## **Stage 2 – Martin Place North (SSD 9270) and South Sites (SSD 9326) Over Station Developments**

Thank you for your correspondence dated 8 October 2018 which invites the City of Sydney ("the City") to provide comment on State Significant Development (SSD) Applications 9270 and 9326.

The City has reviewed the stage 2 detailed applications for over station tower developments and based on the submitted information **objects** to the proposals in their current forms.

Outline of shadow cast by North Site  
Stage 1 SSD DA building envelope

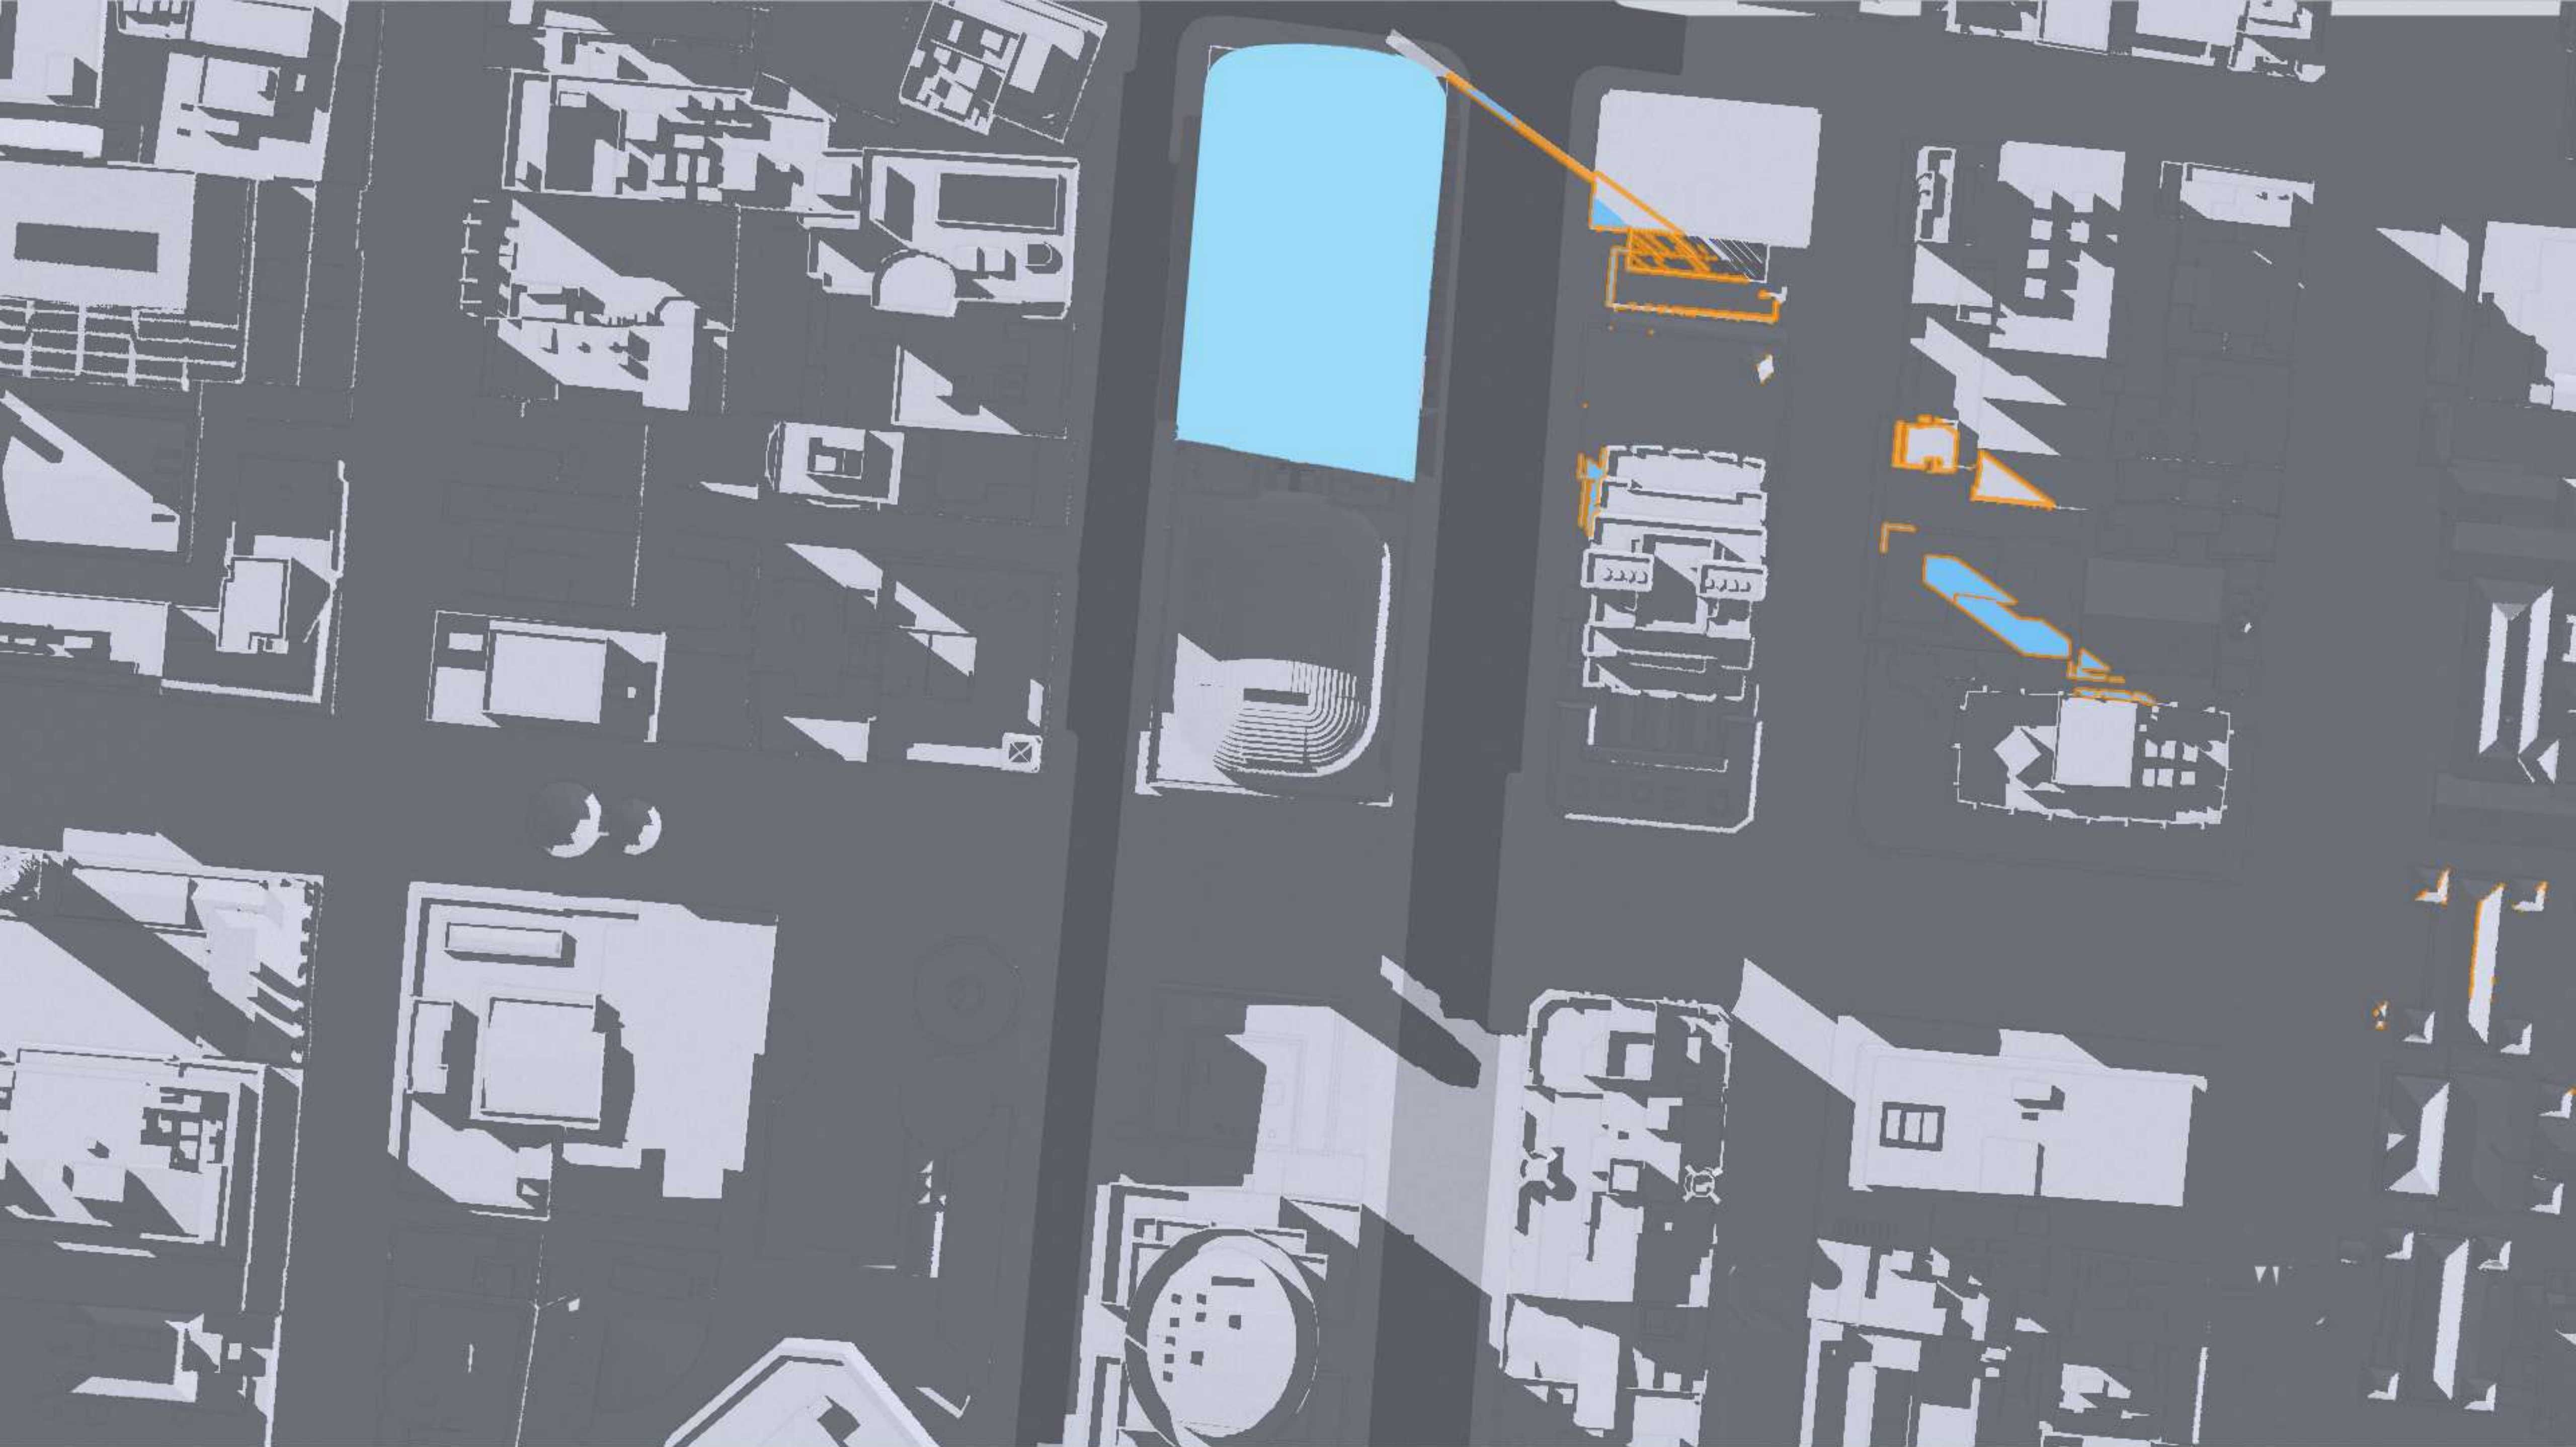
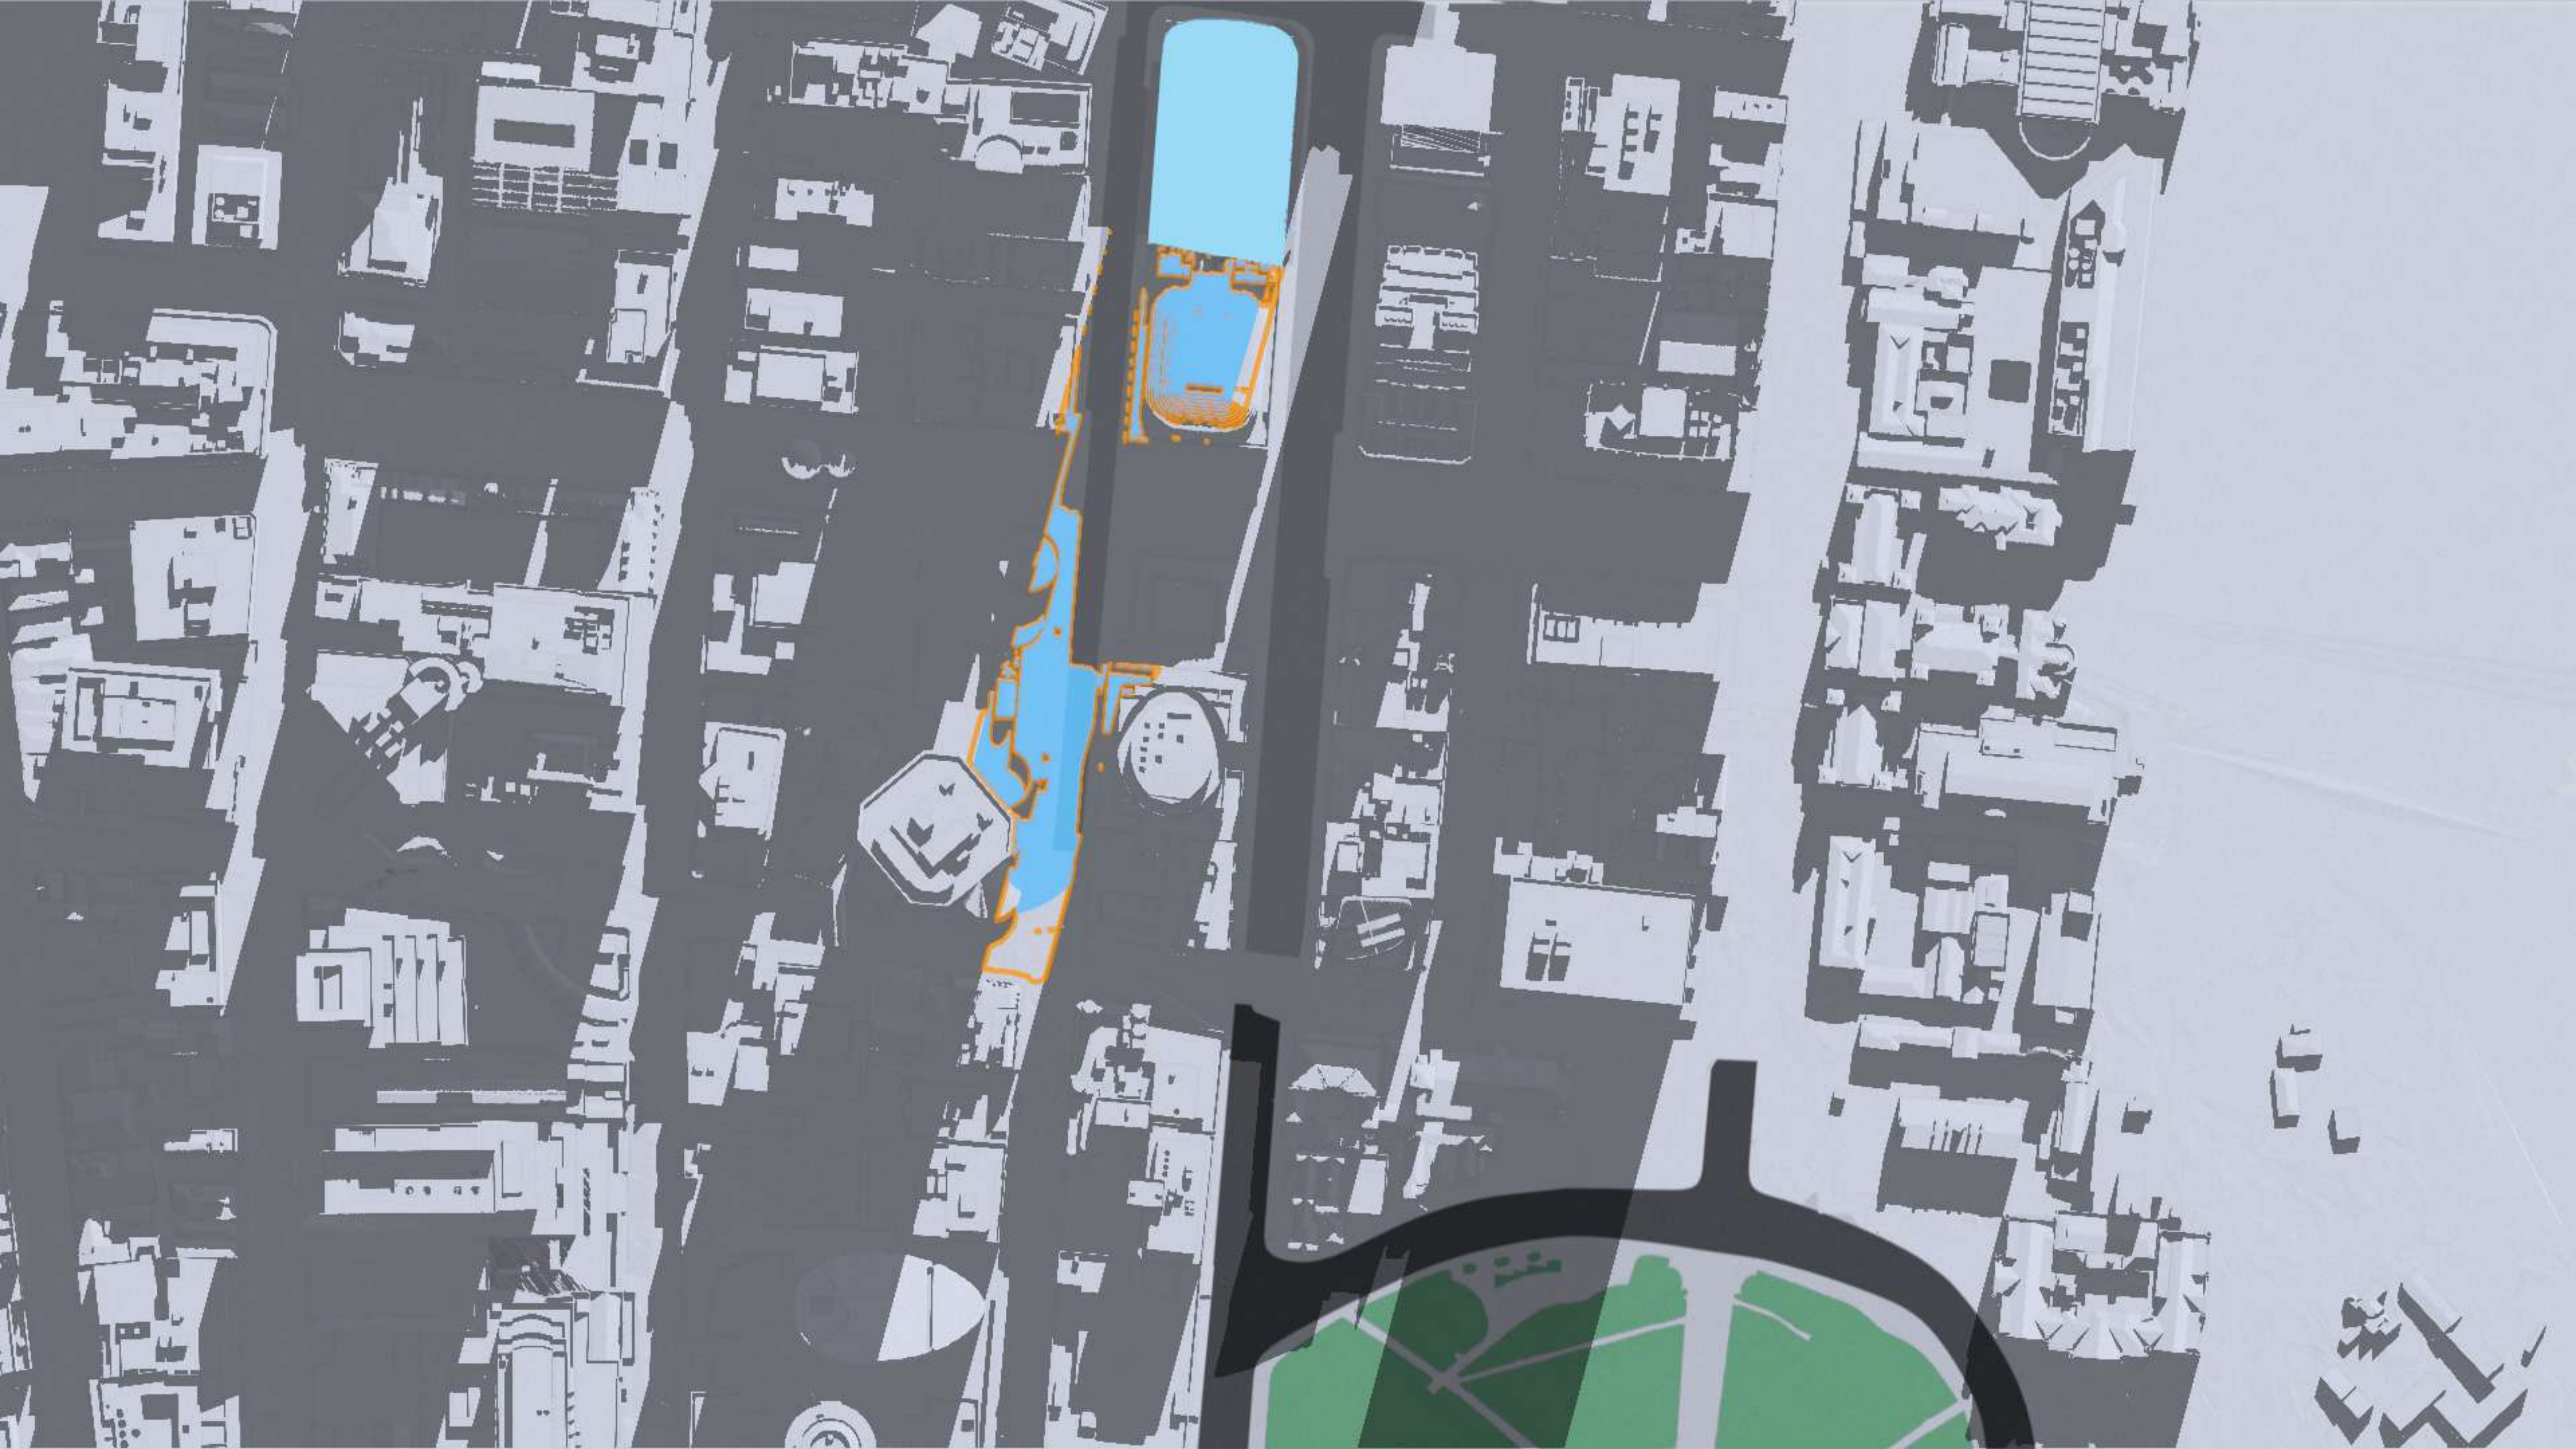
The proposed building form of the north tower is incongruous to the character of central Sydney and the Martin Place Special Character area. The City recommends that the northern tower be setback by at least 8m from all street frontages above the podium height of 50 Martin Place. In particular a setback above the podium is essential for Elizabeth Street frontage to address overshadowing of Martin Place which is avoidable.

End of Trip Facilities - Level B2 Plan, by Grimshaw

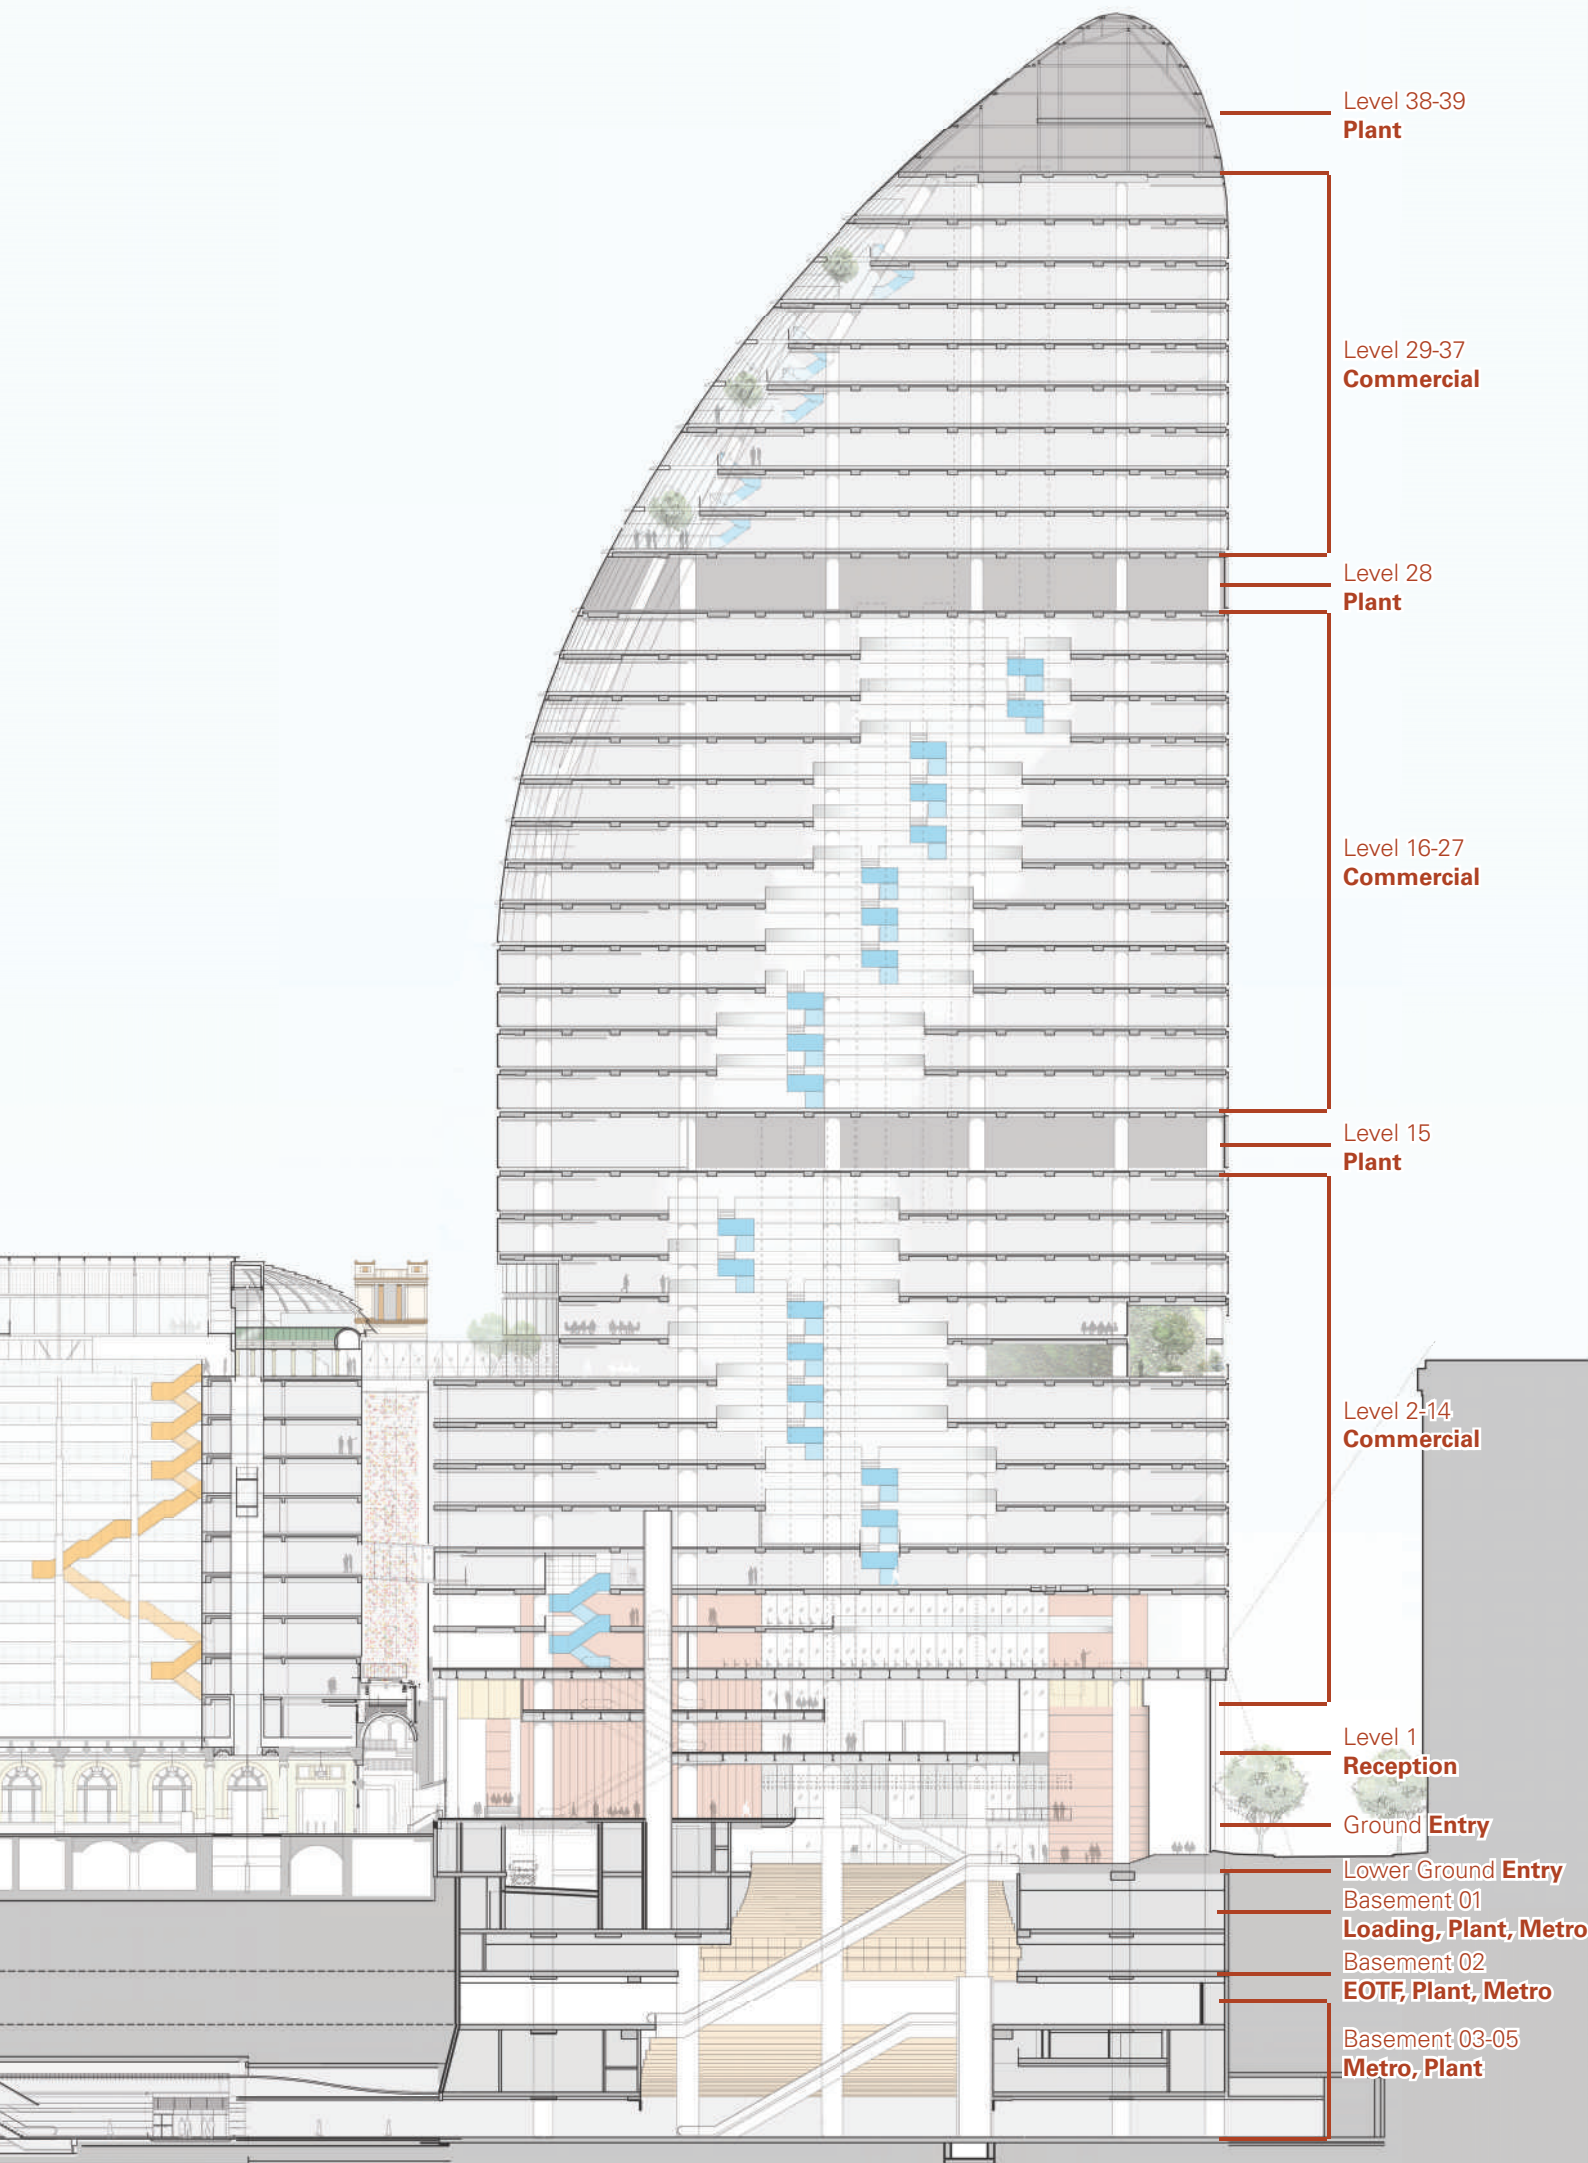
The applications include the provision of bicycle parking, loading and end of trip facilities for the south site within the basement of the north site (literally an entire street block away).

The provision of the bicycle parking and end of trip facilities in a different building a block away is not supported. The City recommends that the southern basement be redesigned to fully accommodate the required parking and facilities. Bicycle parking and end of trip facilities should be provided in accordance with Sydney DCP 2012.
